**Application Reference:** 2025/0986

**Site Address:** 9 Galway Close, Royston, Barnsley, S71 4FR

**Introduction:** Erection of a two-storey side extension and installation of tiled roof on existing rear conservatory

Ref.	Dwg. No.	Rev.
2025/175	02	B

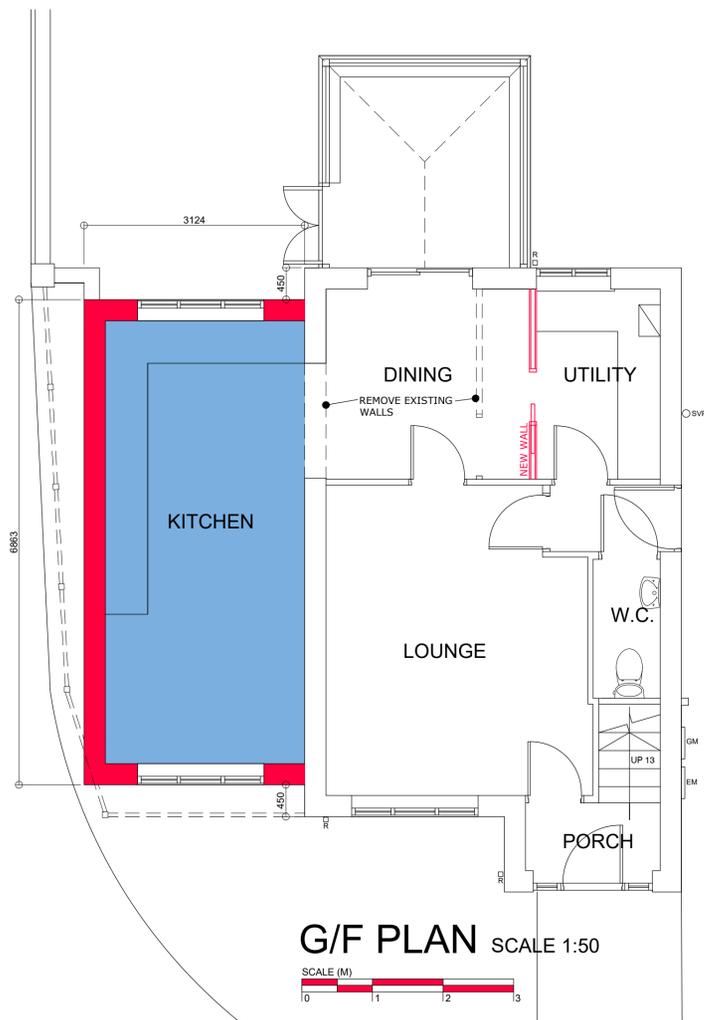
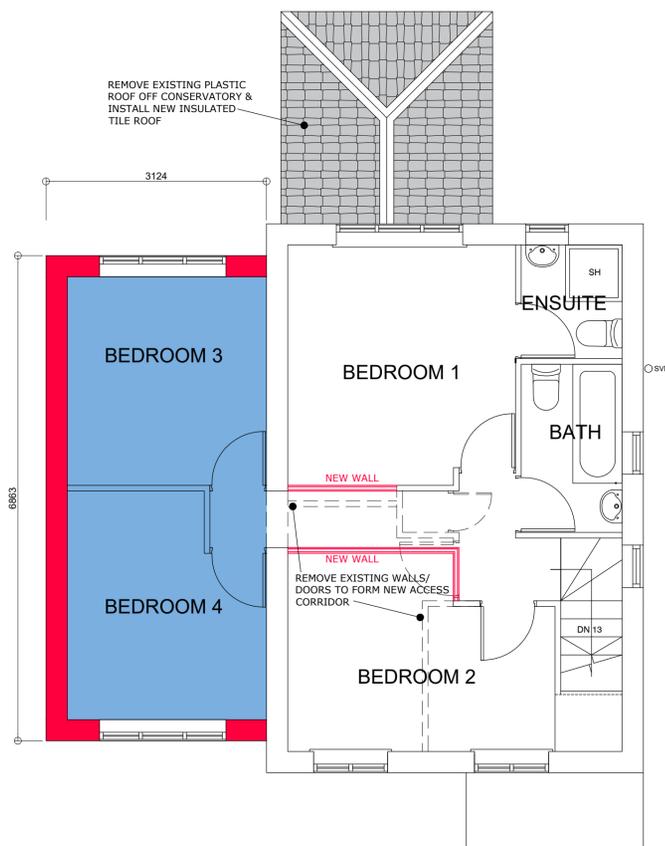
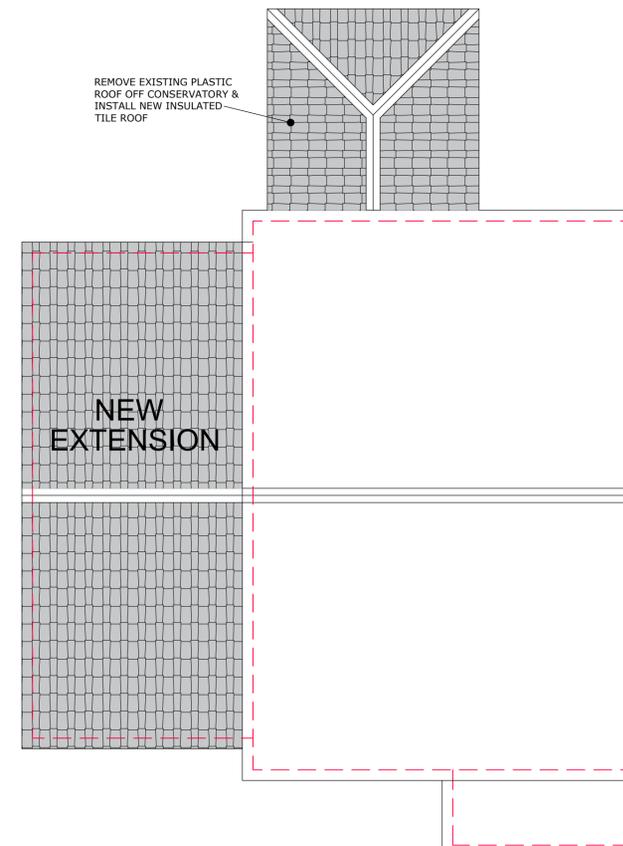
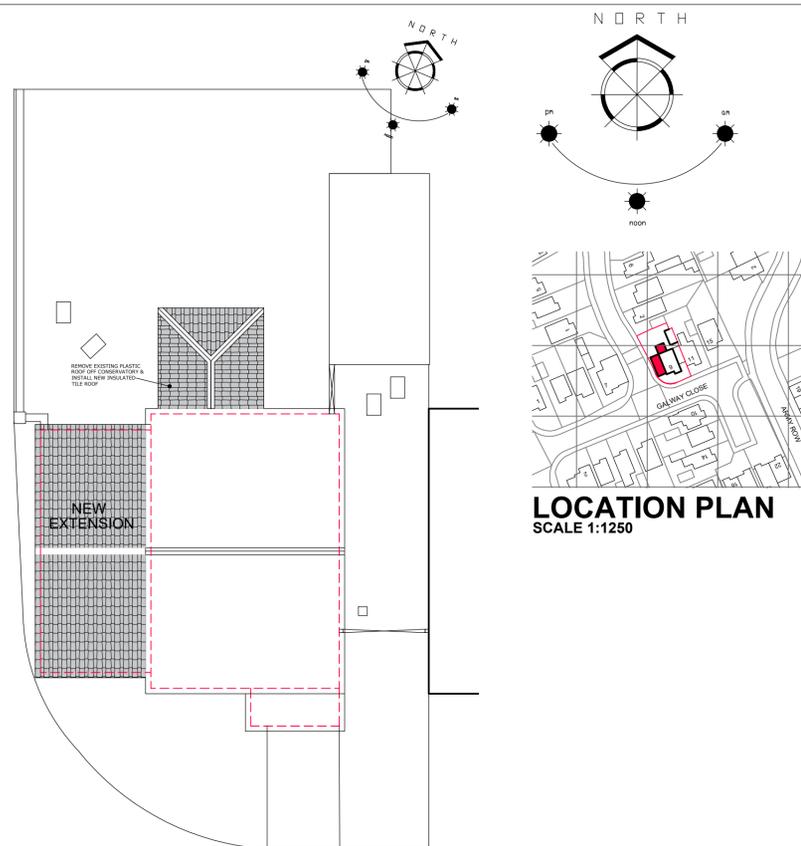
The proposal details a sideways projection of approximately 3.1 metres. Although it is acknowledged the proposal does not provide a projection which is half the distance between the dwelling and the boundary, given the adjacent property (7 Galway Close) provides a similar side extension and projection (as shown below), the proposal is considered acceptable on this occasion. It is noted that 7 Galway Close gained approval in 2012 prior to the adoption of the current SPD, however, the proposal would be very similar to that extension and would reflect the character of the streetscene. As such, a refusal could not be supported in this instance, despite the conflict with the SPD. Each case has to be determined on its own merits.

The proposal provides a setback of 0.45 metres from the front elevation and the rear elevation. The ridge of the extension is also set down from the existing dwelling. These elements allow the extension to remain subordinate to the existing dwelling. A pitched roof form is proposed which allows the proposal to remain in keeping with the character of the dwelling and the street scene.

It has been necessary to make contact with the applicant to request the proposed rear elevation to be set back from the rear elevation of the existing dwelling in order to provide a proposal which is more compliant with the House Extensions SPD. Amendments were received on the 11<sup>th</sup> January 2025.
